KITTITAS COUNTY

MEMORANDUM

SUBJECT: McMechan Trust Short Plat SP-09-00011

Thank you for the opportunity to comment on the short plat of approximately 12.53 acres into 4 lots, proposed by Clay Mc Mechan [SP-09-00011]. We have reviewed the application and have the following comments.

McMECHAN TRUST SHORT PLAT
PART OF SECTION 9, T. 17 N., R. 18 E., W.M.
KITITAS COUNTY, WASHINGTON

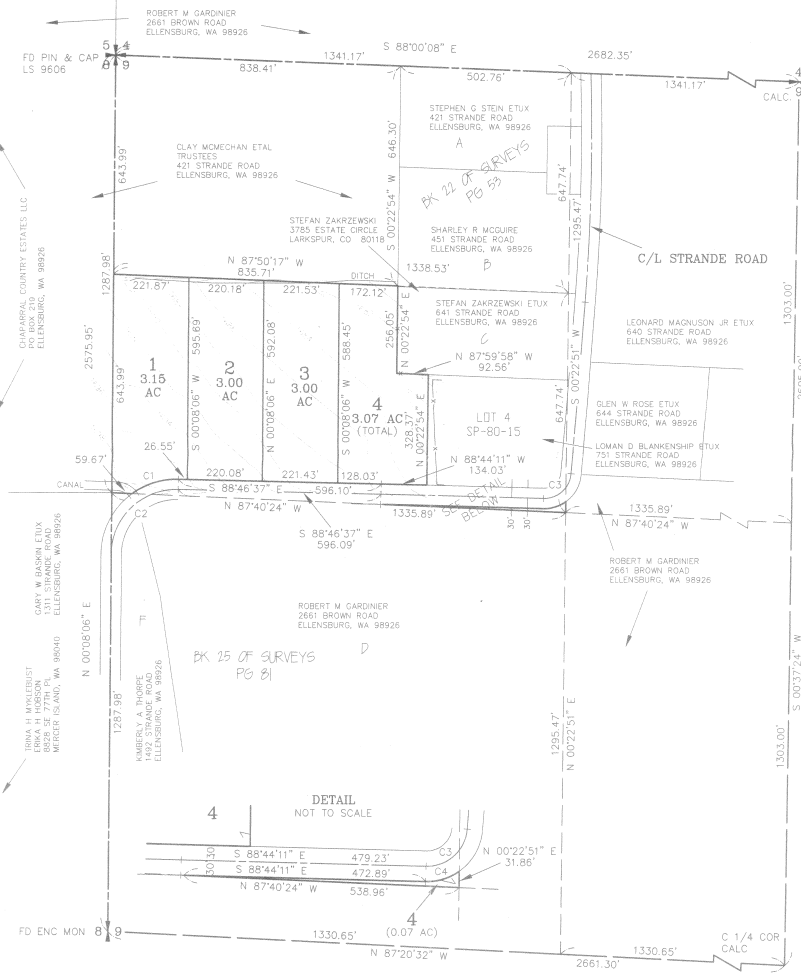
1. Access Permit: An approved access permit shall be required from the Department of Public Works prior to creating any new driveway access or performing work within the county road right of way. Access location shall be determined through the access permit process.
2. Joint-Use Driveway: A joint-use access shall serve no more than two tax parcels. See Kittitas County Road Standards, 9/6/05 edition.
 - a. Access easements shall be a minimum of 20' wide. The roadway width shall have a minimum width of 12'.
 - b. The surface requirement is for a minimum gravel surface depth of 6".
 - c. Maintenance of driveway approaches shall be the responsibility of the owner whose property they serve. The County will not maintain accesses.
 - d. Any further subdivision or lots to be served by proposed access may result in further access requirements.

Single-Use Driveway: A single-use access shall serve no more than one lot. See Kittitas County Road Standards, 9/6/05 edition.

- a. The roadway shall be a minimum of 8' wide with gravel surface.
 - b. Maintenance of driveway approaches shall be the responsibility of the owner whose property they serve. The County will not maintain accesses.
 - c. Any further subdivision or lots to be served by proposed access may result in further access requirements.
3. Private Road Maintenance Agreement: The applicant shall meet all applicable conditions of any pre-established or required Private Road Maintenance Agreements.

The final plat notes shall include the following two statements:

"The approval of this division of land includes no guarantee that there is a legal right to withdraw groundwater within the land division. The approval of this division of land provides no guarantee that use of water under the ground water exemption (RCW 90.44.050) for this plat or any portion thereof will not be subject to curtailment by the Department of Ecology or a court of law. "

"Metering will be required on all new residential well connections and metering results shall be recorded in a manner consistent with Kittitas County and Washington State Department of Ecology requirements."

The Company has no objection to shareholders short platting their property. However, all shares of water are considered tied permanently to the land. It is the shareholder/property owner's responsibility that shares currently attached to the property are equitably distributed to the newly created parcels. Parcels of the size proposed by this short plat must be tightlined from the canal and irrigated by sprinklers. Shareholders are required to order water from a designated headgate, and all headgates are numbered by the Company. Therefore, each new parcel resulting from this short plat, must have the designated, numbered headgate identified in the plat from which it receives its water.
